Harnett County

Permit Number: BCOM2206-0002

Description: New Church 3D Community Church

LIST OF REVIEWS

Fire Alarm System

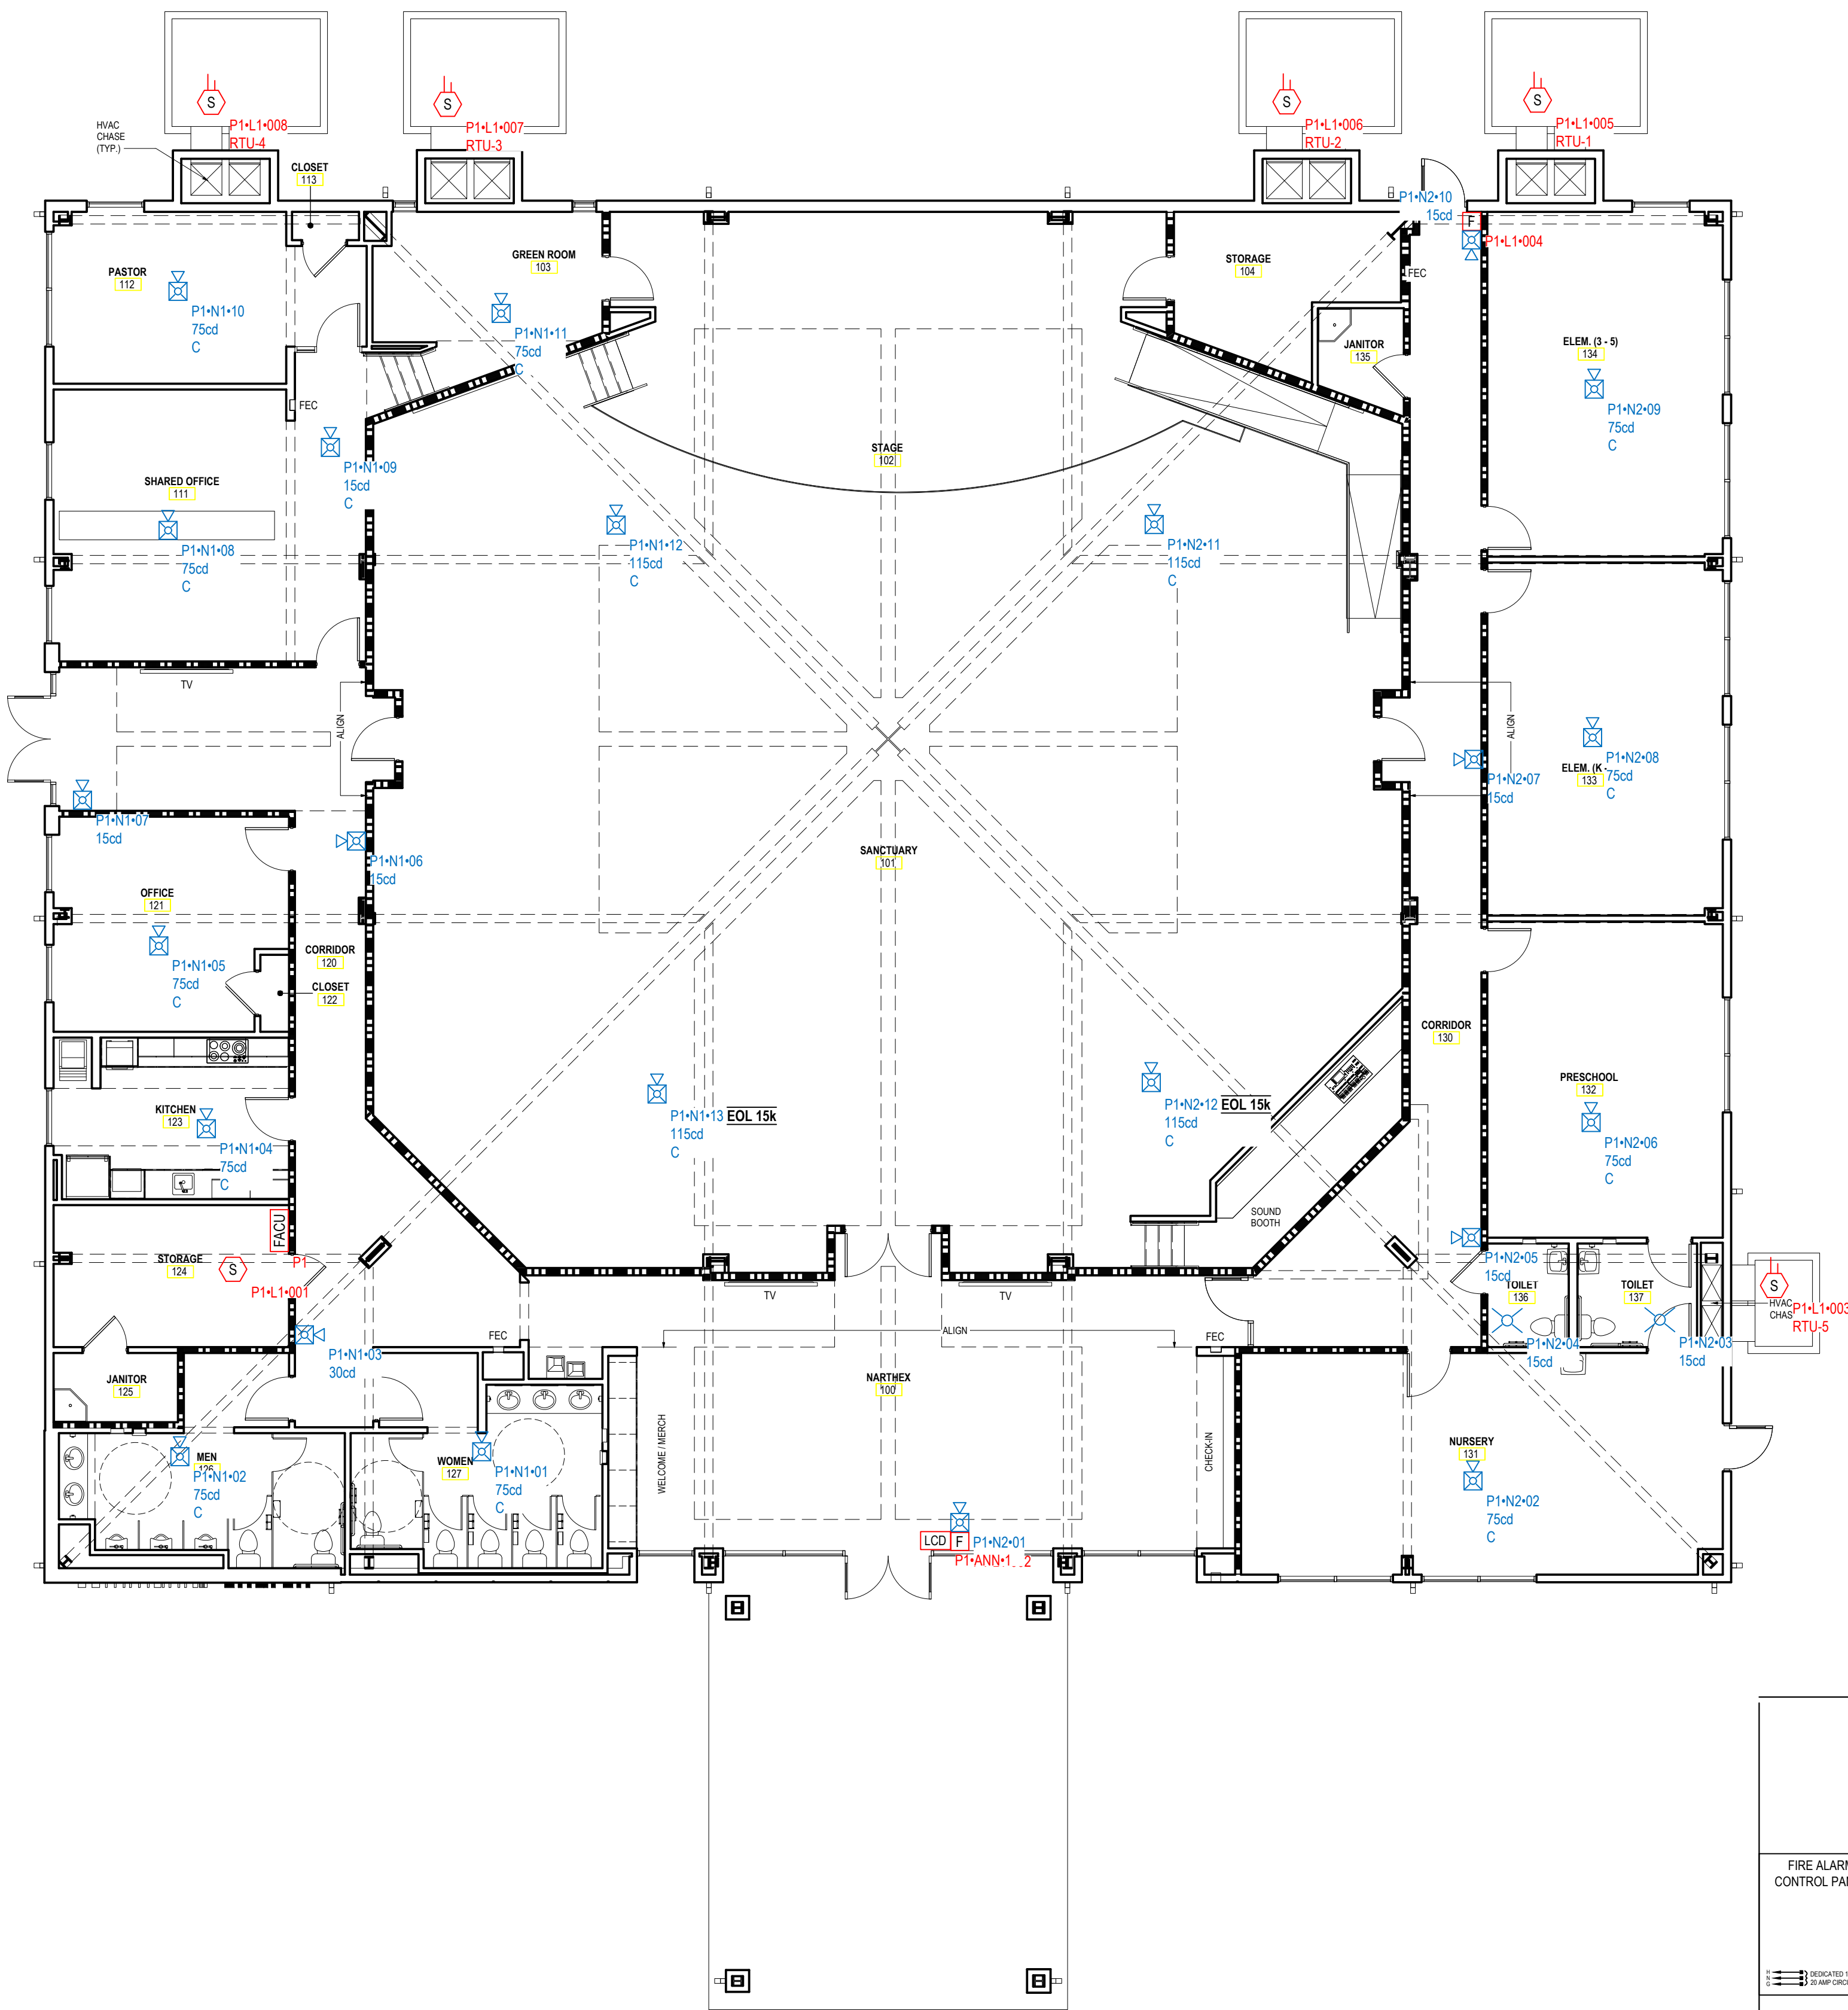
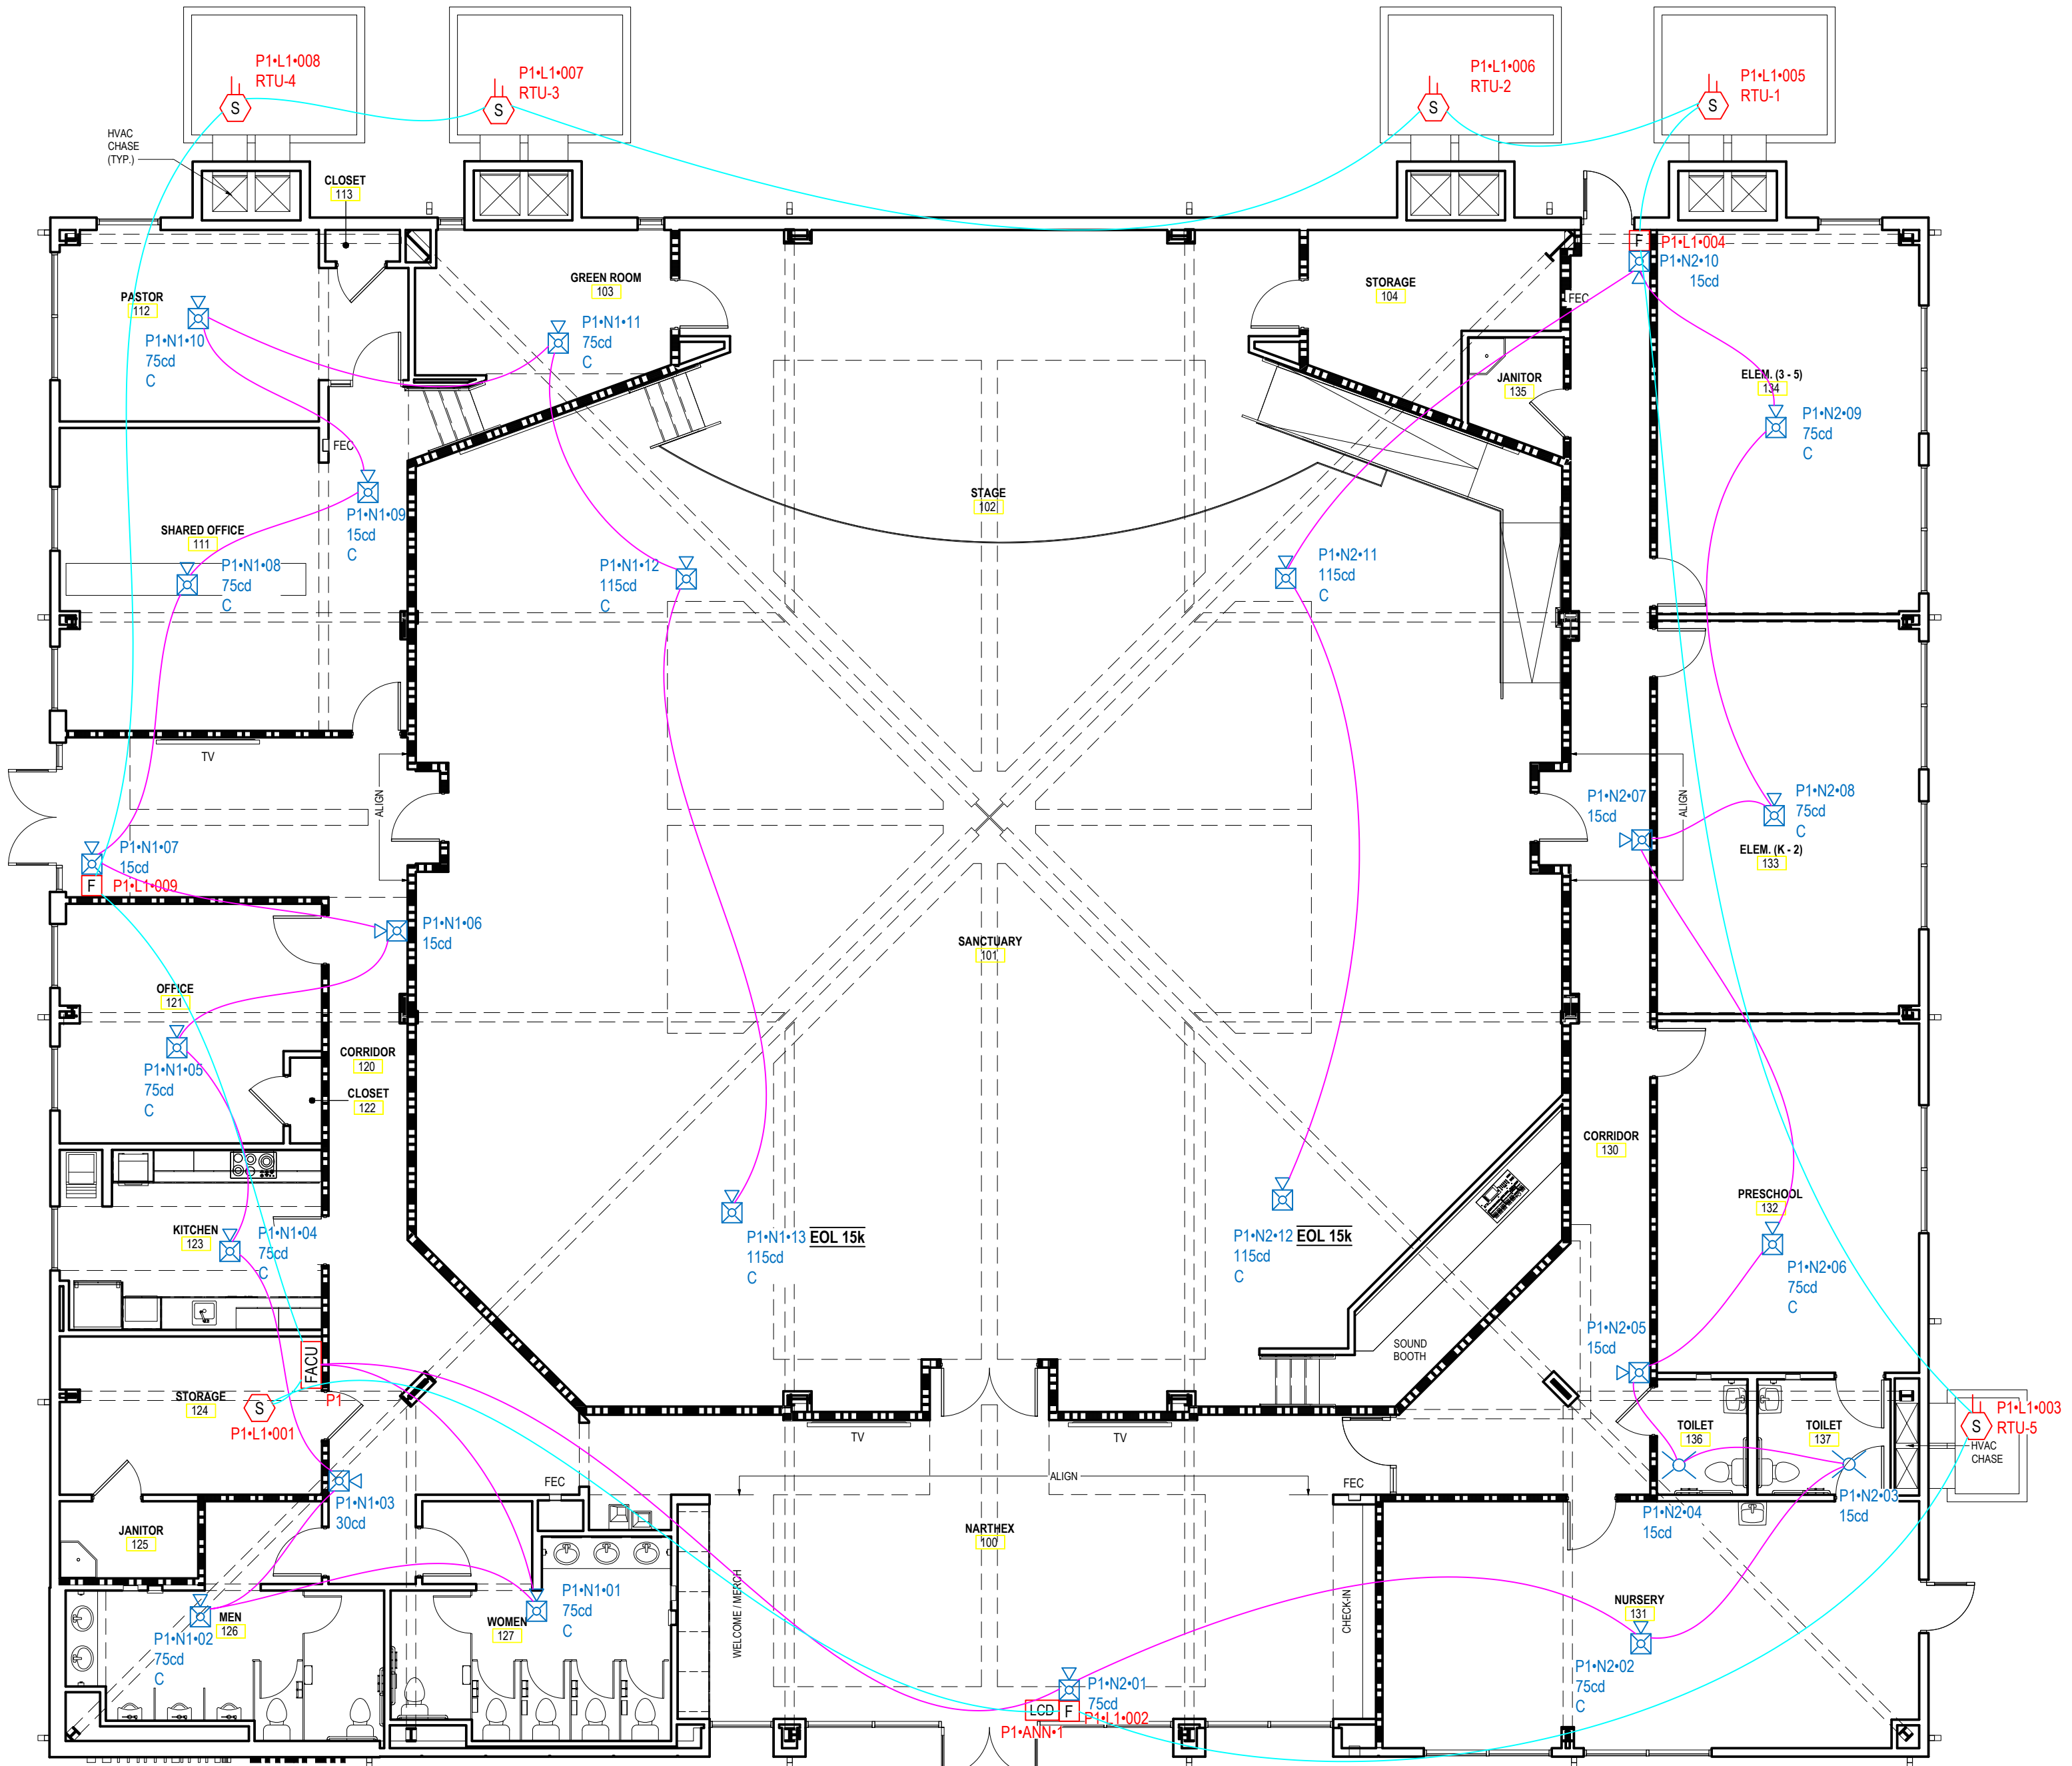
SENT DATE	RETURNED DATE	DUE DATE	TYPE	CONTACT	STATUS	REMARKS
Review Group: ALL						
6/27/2022	7/19/2022		FIRE MARSHAL	Roger Sullivan	APPROVED	
Notes: Need to submit fire alarm plans, see attached letter.						
6/30/2022	7/15/2022	7/15/2022	ENVIRONMENTAL	MARK OSBORNE	UNDER REVIEW	
Notes: Need property lines accurately flagged, irons exposed, and building and parking lot staked off. Soils are PS						
Review Group: AUTO						
6/9/2022	3/28/2023		COMMERCIAL INTAKE	CP Bucket	DISAPPROVED	
Notes:						
6/15/2022	6/27/2022	6/29/2022	COMMERCIAL BUILDING REVIEW	Brad Sutton	DISAPPROVED	X2
Notes: 1. Correct square footage of building shown on Appendix B 2. Sanctuary must have a 2 HR separation from the remainder of the building. Doors must be so rated. 20 min doors shown. 3. Sheet A-1 has text over text, also remove irrelevant notes. 4. Classroom 126 does not show access? 5. Three different occupant loads shown on plan. Life safety calculates to 516, Arch plan shows 503, mechanical OAI calculated for 490 people. 6. Page E-3 is not full size/scaled. Provide corrected sheet.

TYPICAL FIRE HYDRANT INSTALLATION DETAIL

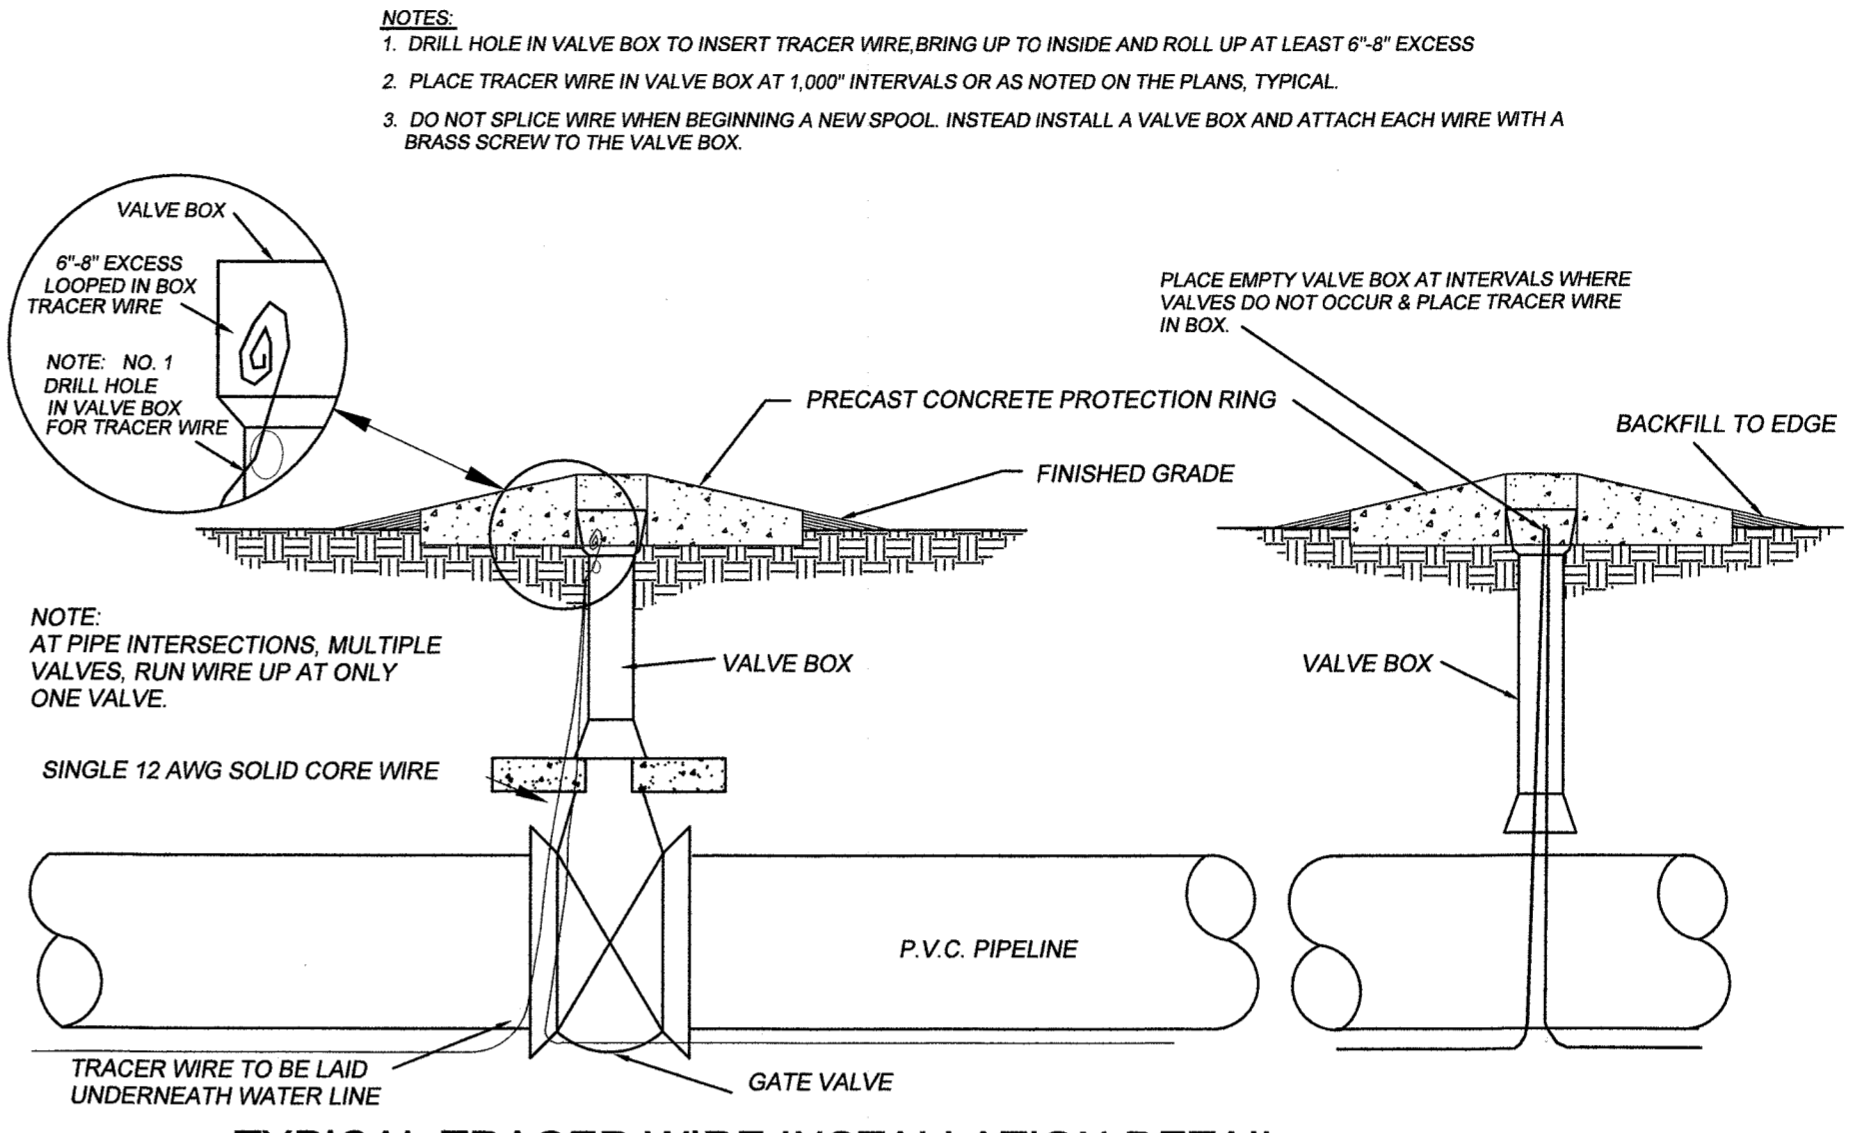
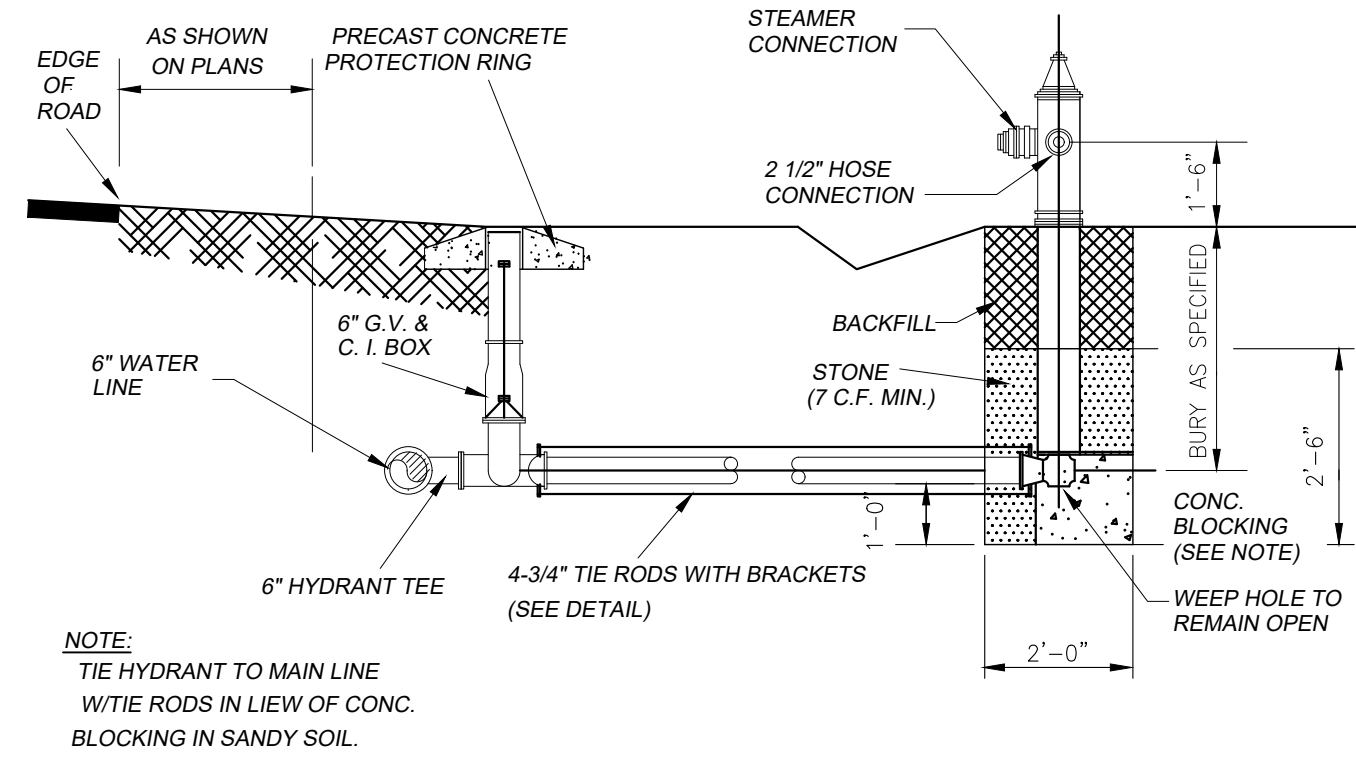
6/15/2022	6/29/2022	6/29/2022	FIRE MARSHAL	Leslie Jackson	DISAPPROVED	See Notes
Notes: 1 - The proposed fire hydrant needs to be accessible from driveway. 2 - Fire hydrant within 400ft of the building measured from center line of the road to the driveway entrance on no less than a 6in water line. 3 - 20ft all weather access. 4 - Appendix B has wrong square footage. 5 - Electrical plan not to scale. 6 - Showing different Occupancy loads. Disapproved LJ						
6/27/2022	7/27/2022	7/25/2022	Commercial Building Review	Brad Sutton	APPROVED	
Notes:
